Our Ref: M/86/17/PL
Your Ref:

Town & Country Planning Act 1990 (as amended)
Town and Country Planning (Development Management Procedure) (England) Order 2015
Application for Planning Permission

Development Retention of salon, erection of first floor extension & two storey rear extension to create 1 No. dwelling.

Location 74 Elmer Road Middleton on Sea

BLOCK PLAN (1:500)

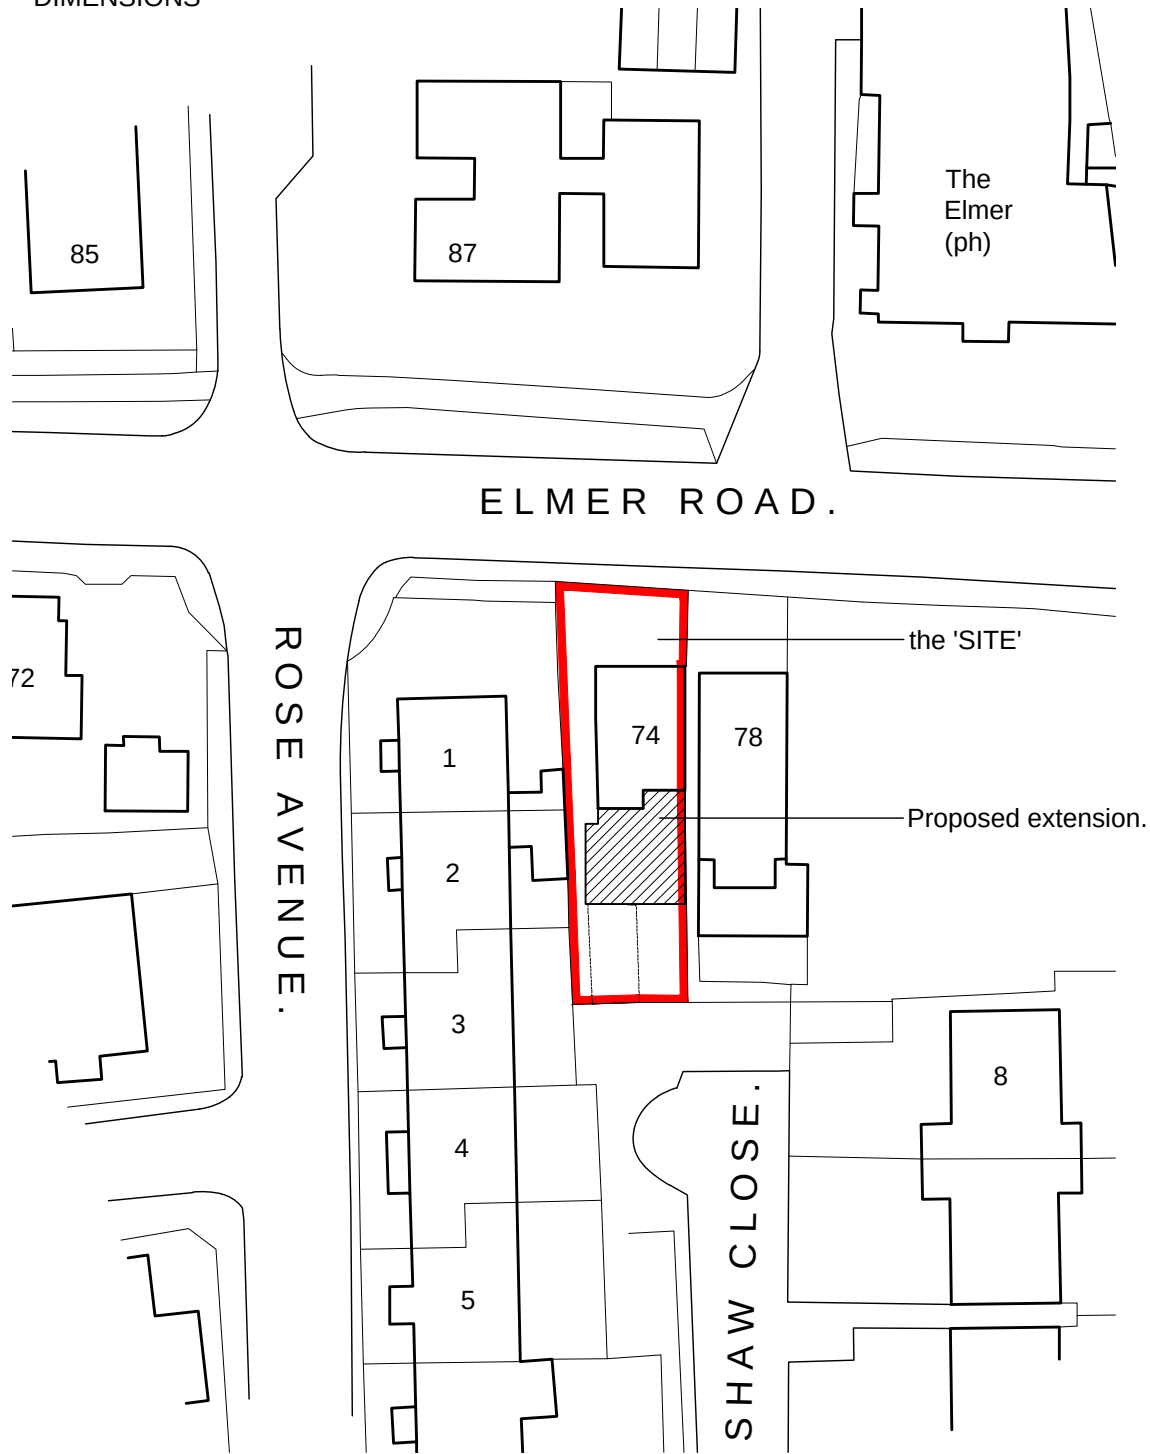
Block Plan Amend

Please submit 1 electronic or 3 paper copies of a block/site plan at a scale of 1:500 or 1:200. Further details of what must be included on the plan can be found in the National Validation Requirements. Please highlight all proposed works, provide dimensions from the rear extension to the site boundaries, show the position of the bins and show the parking spaces.

PROPOSED ELEVATIONS

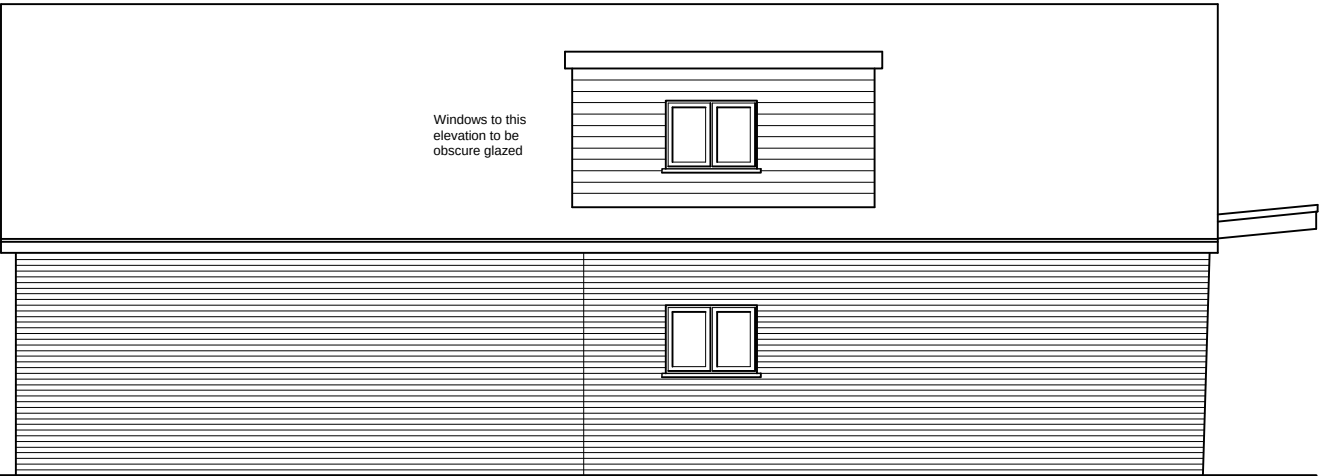
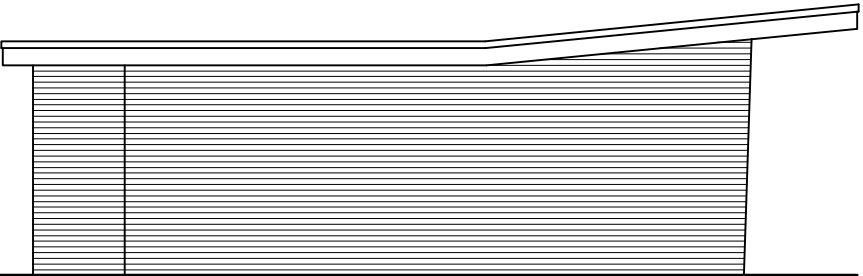
The proposed ground floor east elevation and floor plan do not accord. Please amend accordingly.
